Our ref: DOC19/672812-9

Maxwell Underground Coal Mine Project (SSD-9526)

BCD's recommendations

MAXWELL PROJECT
 Extent of Predicted Alluvial Drawdown

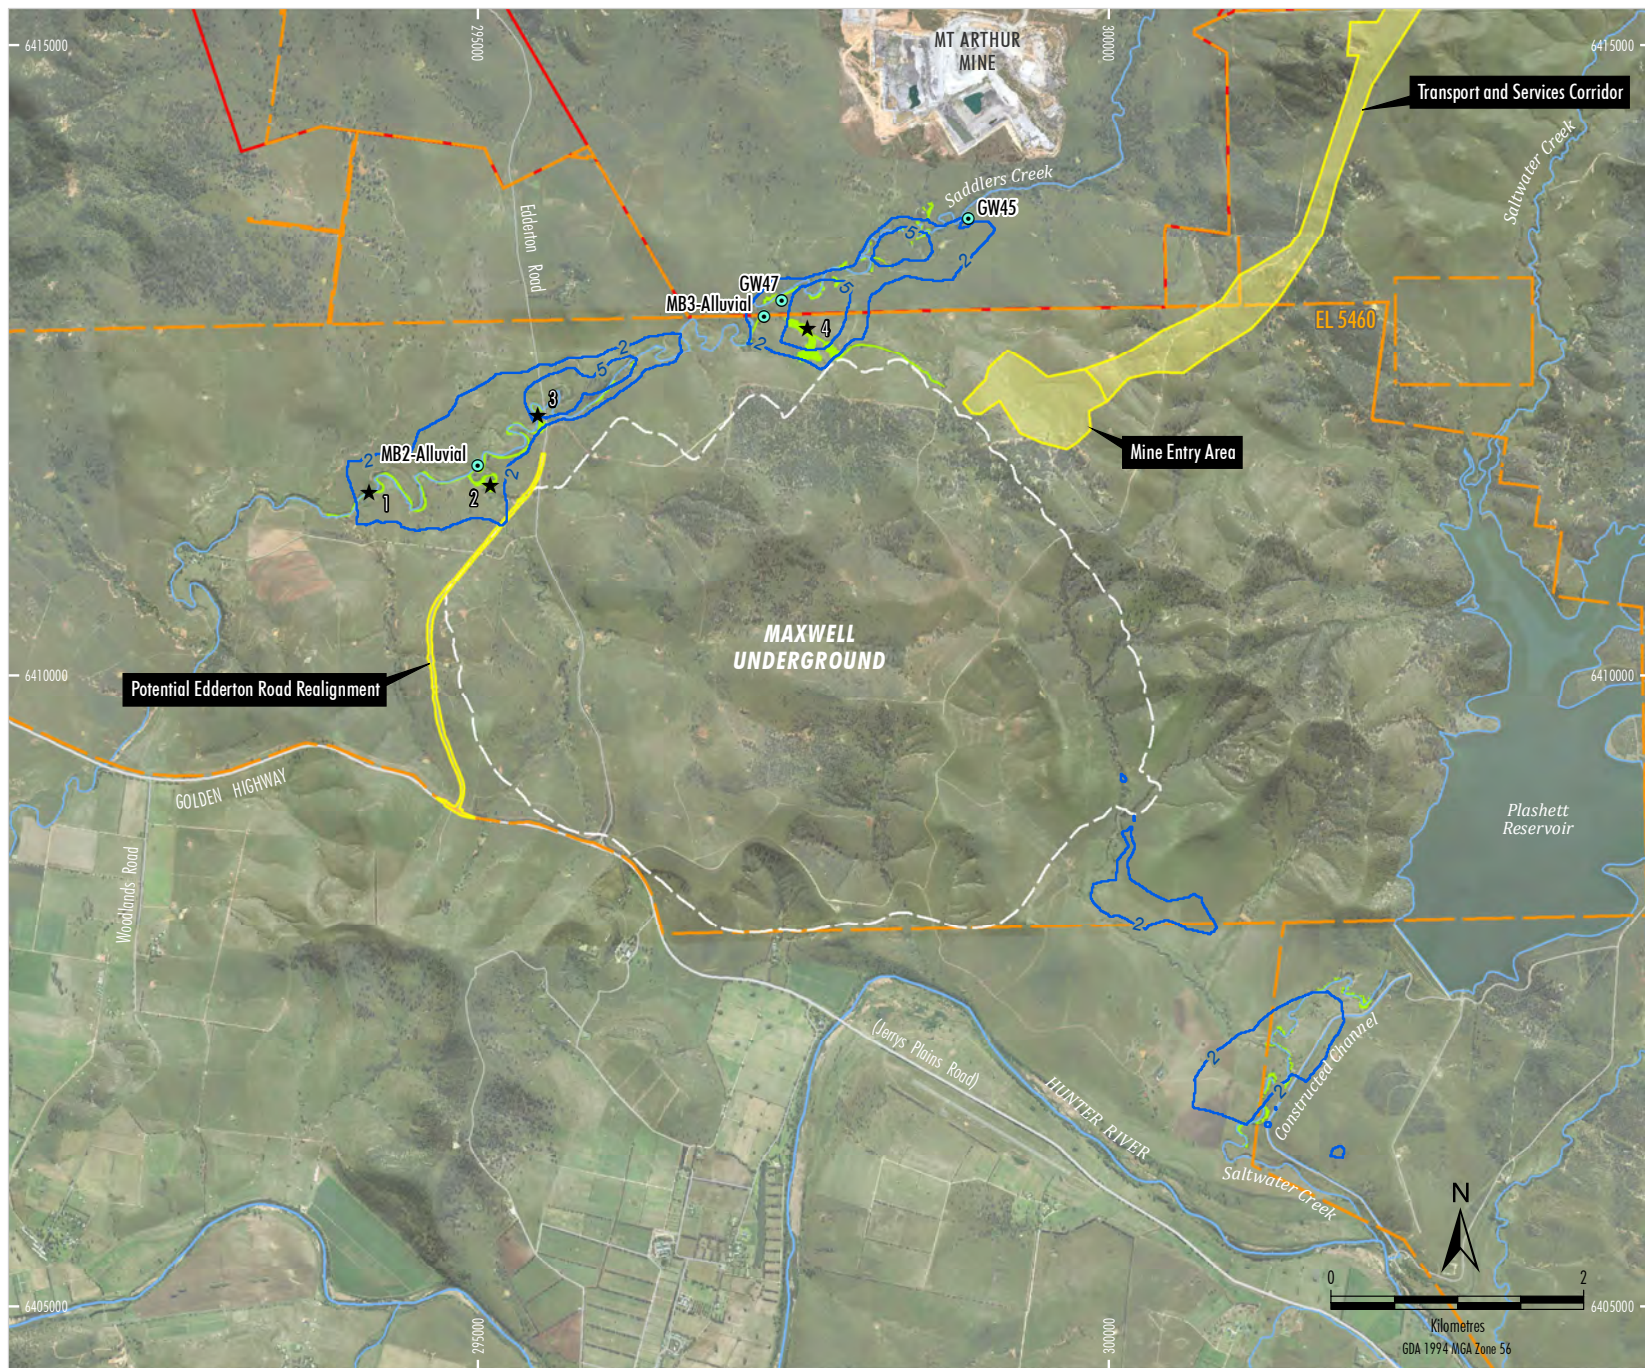
The proposed reduction in groundwater tables along Saddlers Creek and Saltwater Creek represent an uncertain impact on creek line vegetation. BCD recommends that adaptive management is applied to the health of vegetation along those creeks, so that they are monitored, and where changes to the health of such vegetation is detected, any harm is assessed by the BAM and any credits generated are appropriately offset.

Impacts to vegetation growing in Saddlers Creek and Saltwater Creek streambeds should be assessed in accordance with the BAM and any credits generated should be appropriately offset.
